**KIRKLEES METROPOLITAN COUNCIL  
INVESTMENT & REGENERATION SERVICE**

Reference No:	<b>2023/44/93236/W</b>
Site Address:	Pentlands, New Mill Road, Holmfirth, HD9 7LN
Description:	Discharge of conditions 4 (internal estate road details), 5 (parking bay surfacing and drainage), 9 (temporary waste measures), 11 (surface water drainage details), 12 (overflow event scenario), 13 (separate drainage), 15 (temporary drainage measures), 22 (ecological enhancement plan) of previous permission 2020/91896 for demolition of existing dwelling and erection of 15 dwellings with associated access and external works
Recommending Officer:	William Simcock

## Officer Report 2023/93236

### Pentlands, New Mill Road, Holmfirth HD9 7LN

W-2478-23-Pentlands, New Mill Road, Holmfirth

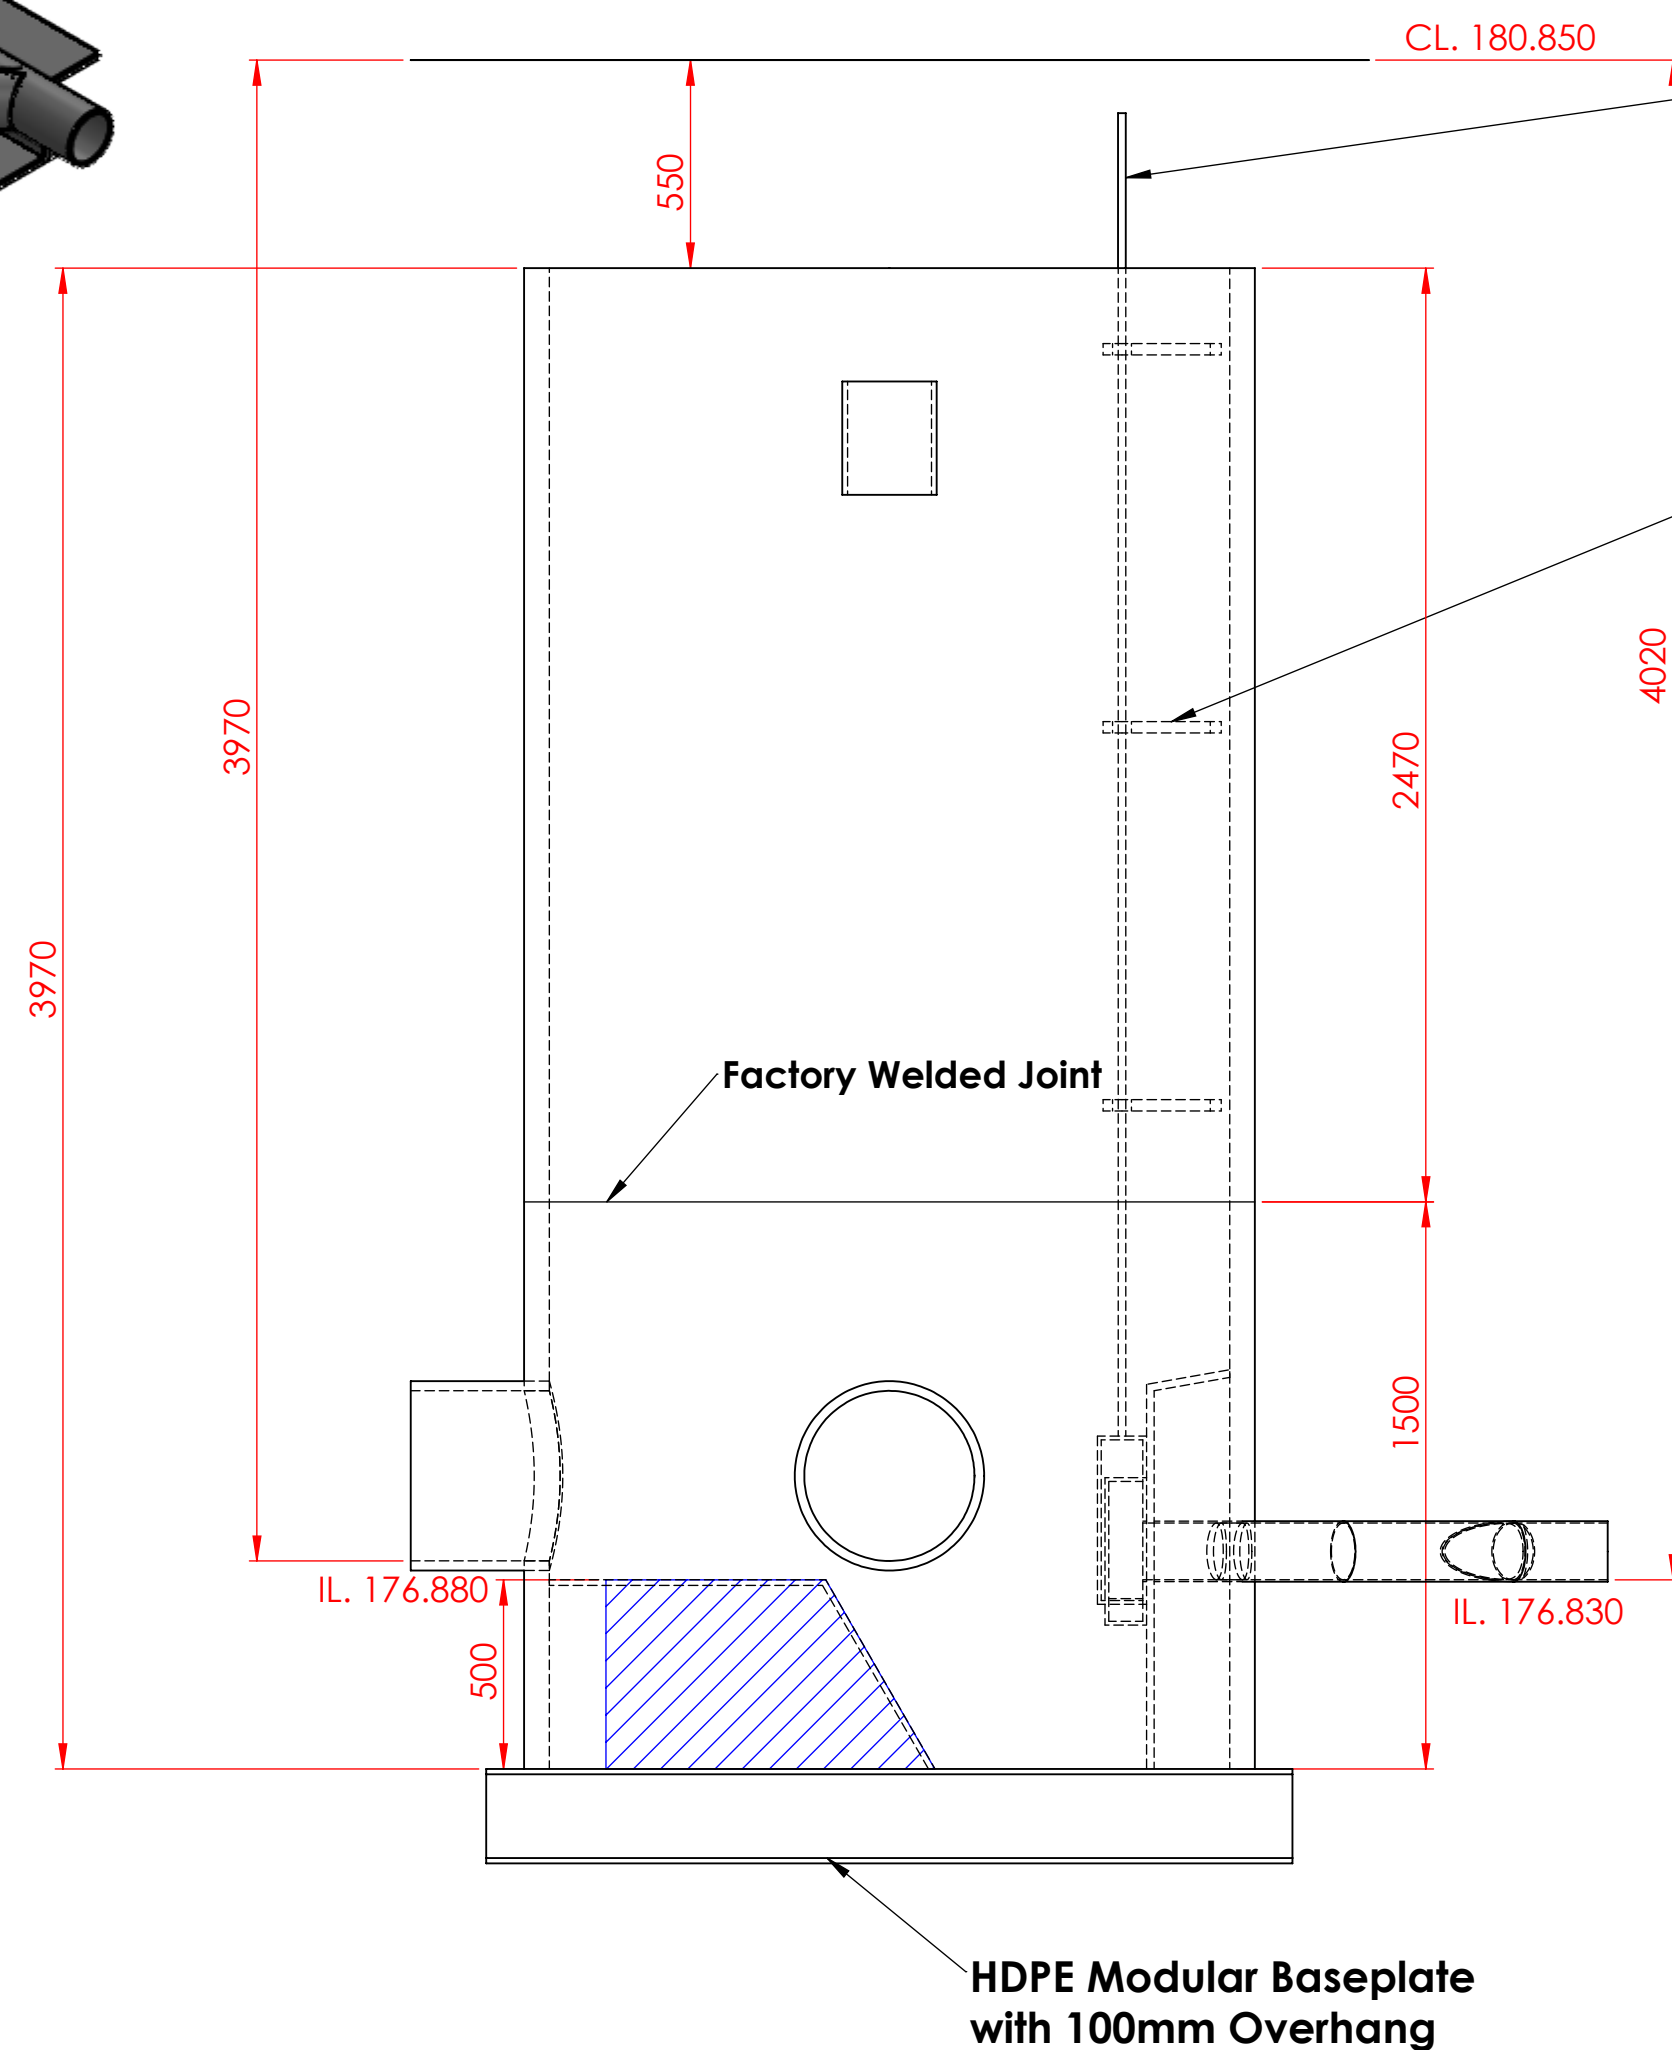
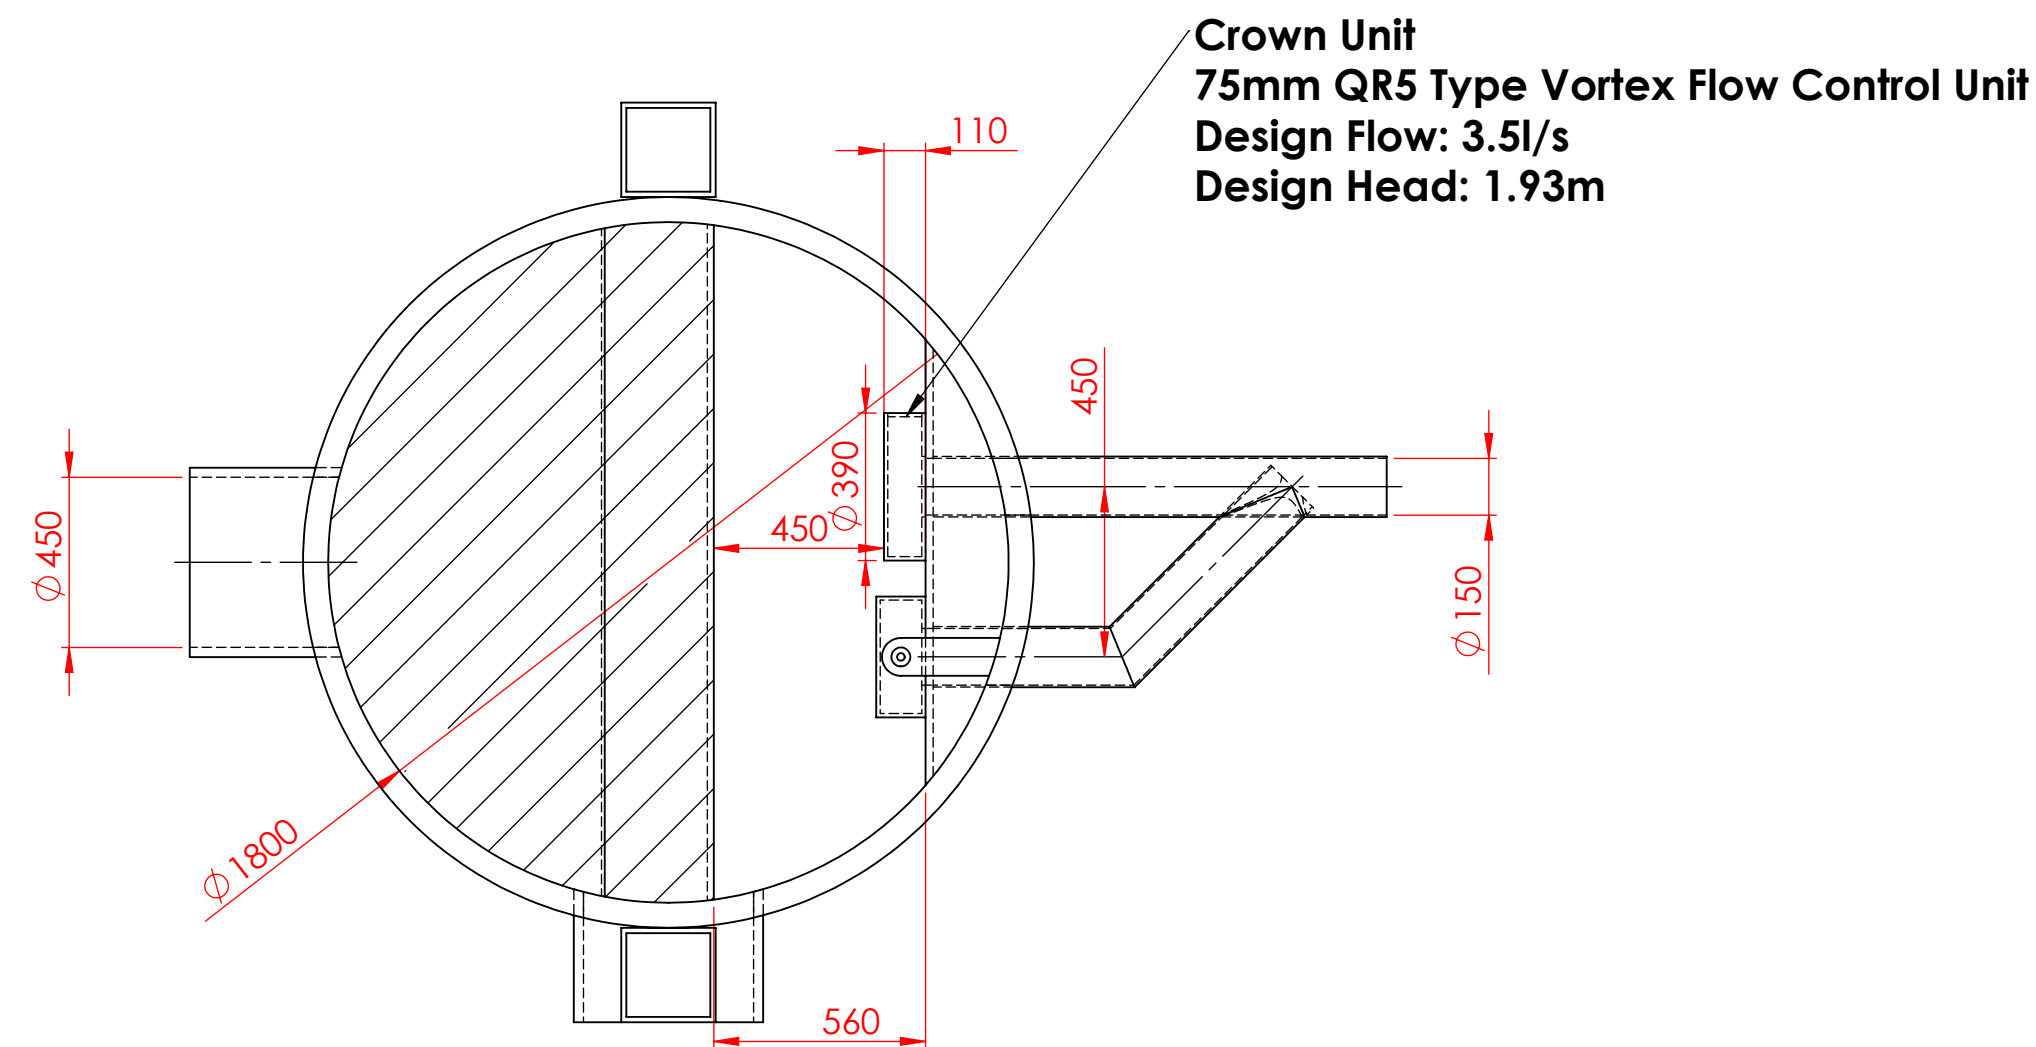
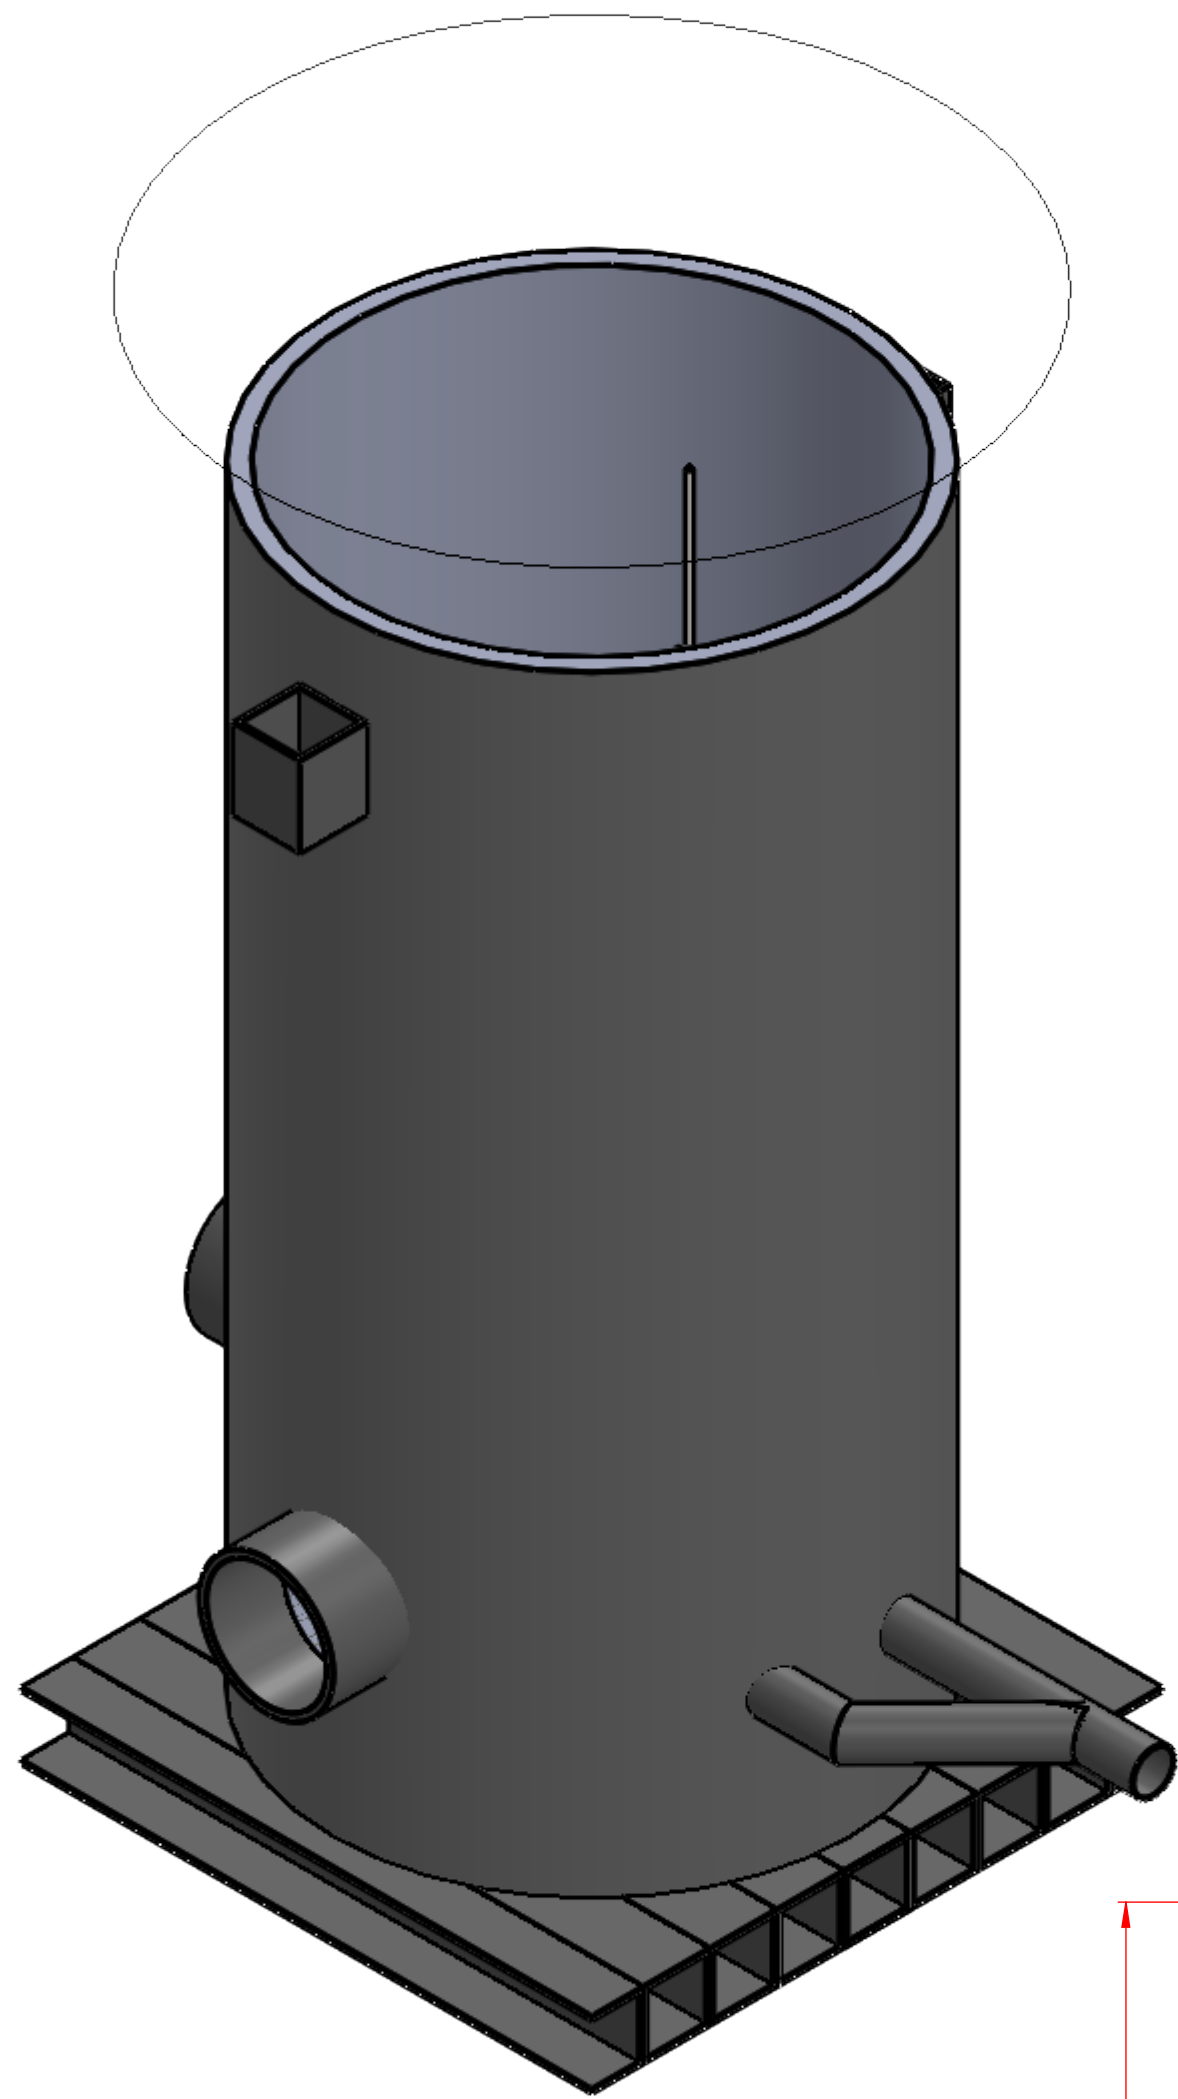
In response to the initially submitted details, the Lead Local Flood Authority (LLFA) raised several concerns, including regarding a lack of clarity on flow control numbers, lack of detail concerning tank design, and absence of a maintenance plan, and also stated that no connection to watercourse on the Midlothian site can be allowed until such a time that the adjacent building site has completed its connection to the open watercourse to the northwest of site.

Additional and amended drawings were submitted (15/02/2024) including attenuation tank details. Yorkshire Water confirm they now have no objections in respect of condition 11. The views of the (LLFA) in respect of the updated plans and details in respect of conditions 11-13 and 15 have been sought, and are awaited. These conditions cannot be discharged at the present time.
